**From:** [clerk@eakringparishcouncil.gov.uk](mailto:clerk@eakringparishcouncil.gov.uk)  
**To:** Great North Road Solar  
**Subject:** Eakring Parish Council Comments  
**Date:** 16 January 2026 14:13:46

Eakring Parish Council

Viewpoint 48  
Ossington Road

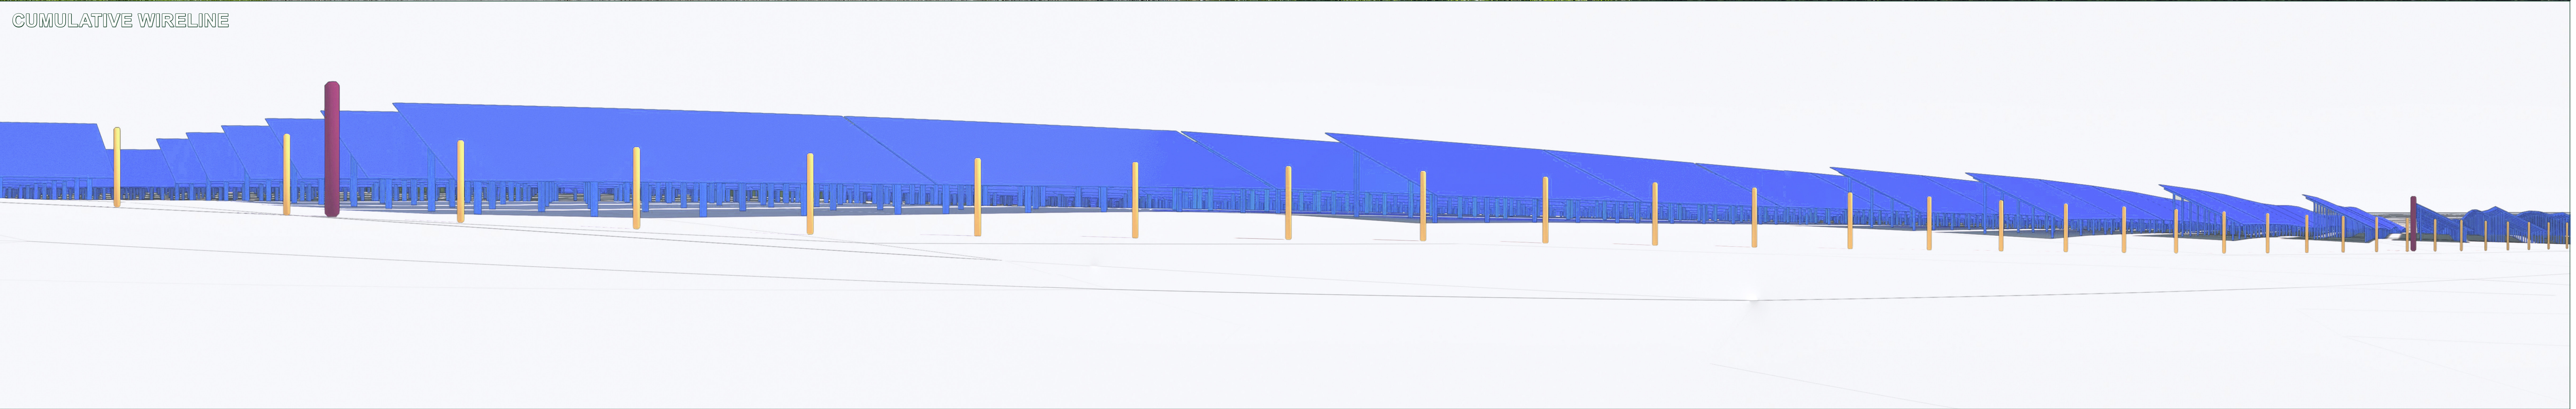
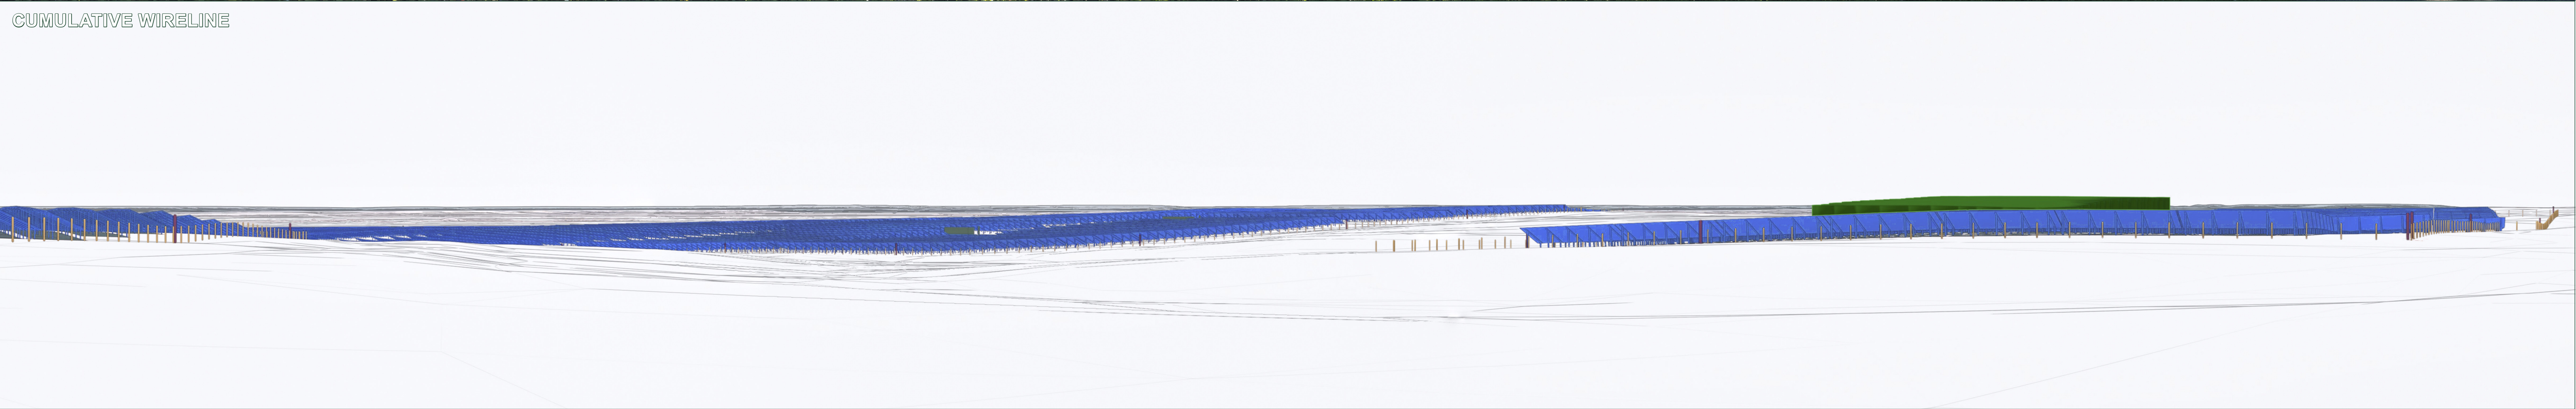
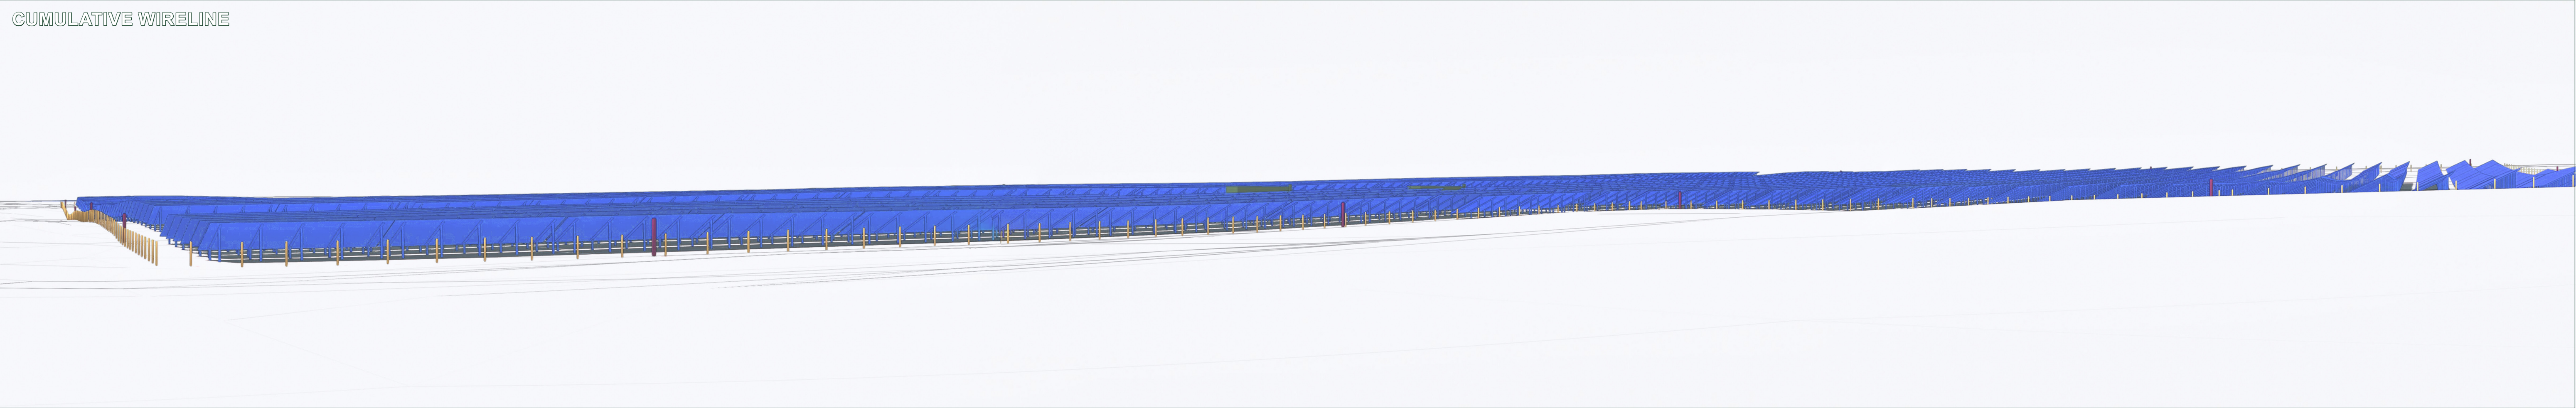
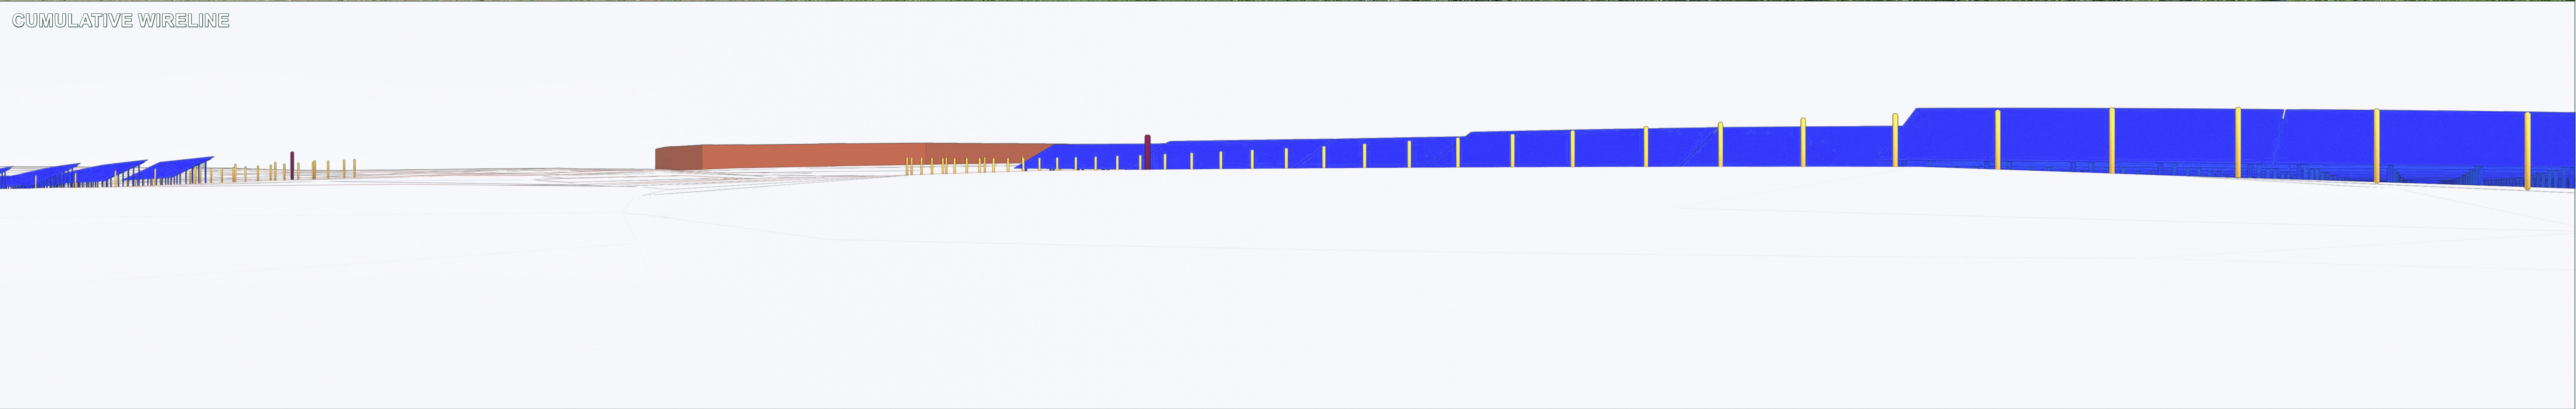
Landscape - There is a negative cumulative impact for Eakring residents and those travelling through Eakring by vehicle, bike etc along the quiet cycle route as defined by NCC and signed by brown signs, (there are solar panels along the entire route from Eakring through to Kneesall, Norwell Woodhouse, Ossington and Sutton on Trent). In addition whichever way people leave Eakring towards Newark they will come across panels. The cumulative impact on the unspoiled countryside that we hold dear has not been taken into account by Elements Green in their submission.
